Subject: 100 Mystic Lane
Lillington, NC 27546
Framing Inspection Letter
Harnett County Permit #: BRES2406-0022

Based on the request of the Contractor, I inspected 1 item in the Screened Porch from the framing inspection notice for code compliance. My assessment and recommendations are as follows:

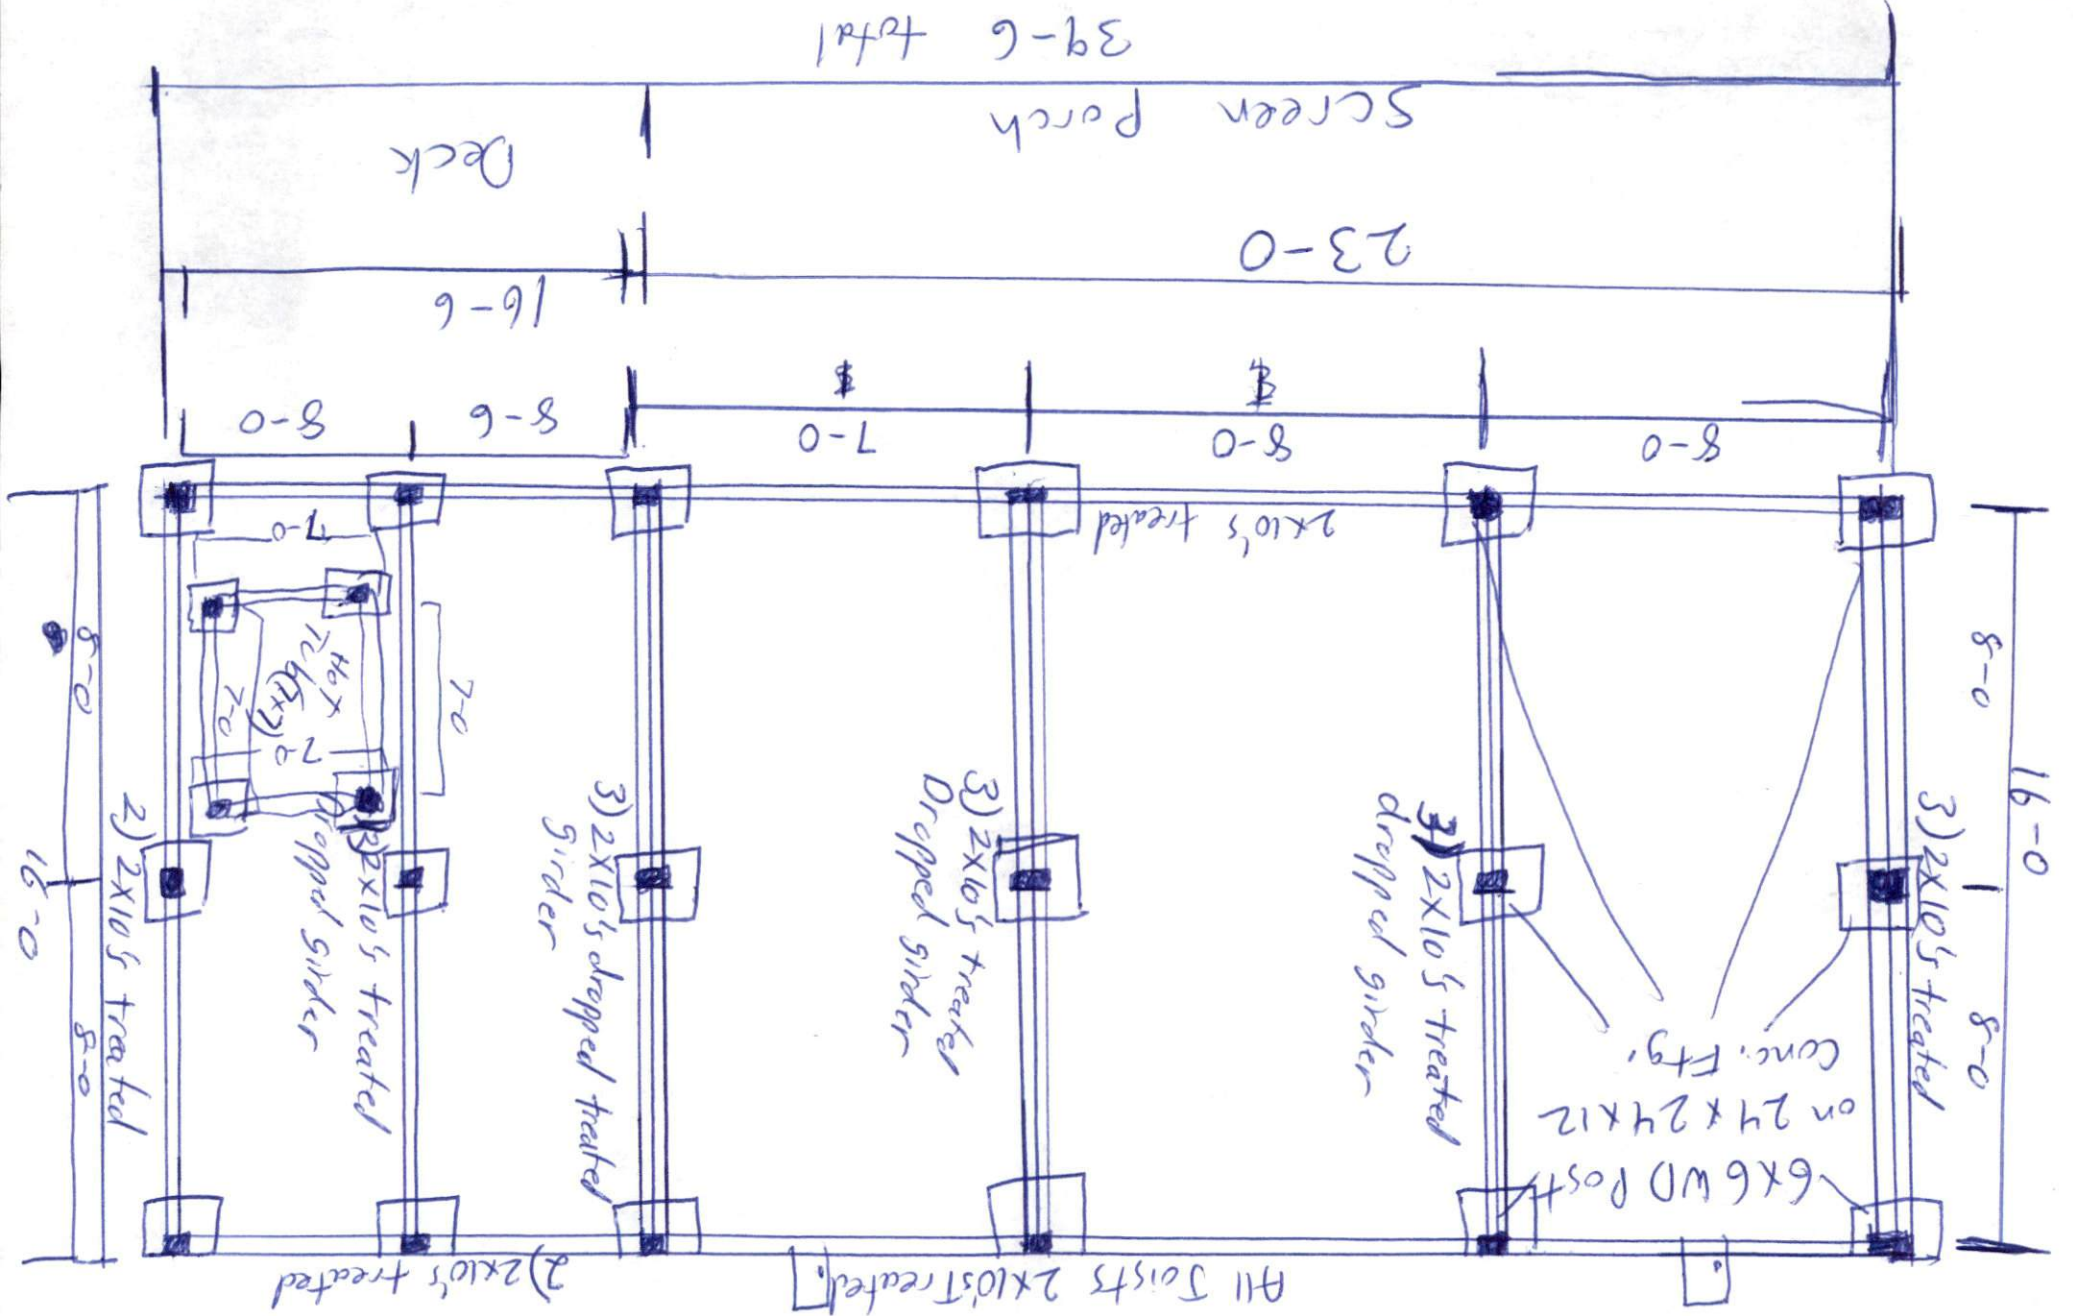
- Item 1: The Contractor has a triple stud column under the double 11 7/8 LVL ridge beam at the connection to the existing home. The triple stud column is bearing on a double 2x10 header in the inset wall above the window. The LVL ridge beam is properly supported at the existing home.

The 1 item noted above meets all the requirements of the 2018 North Carolina Building Code for Residences.
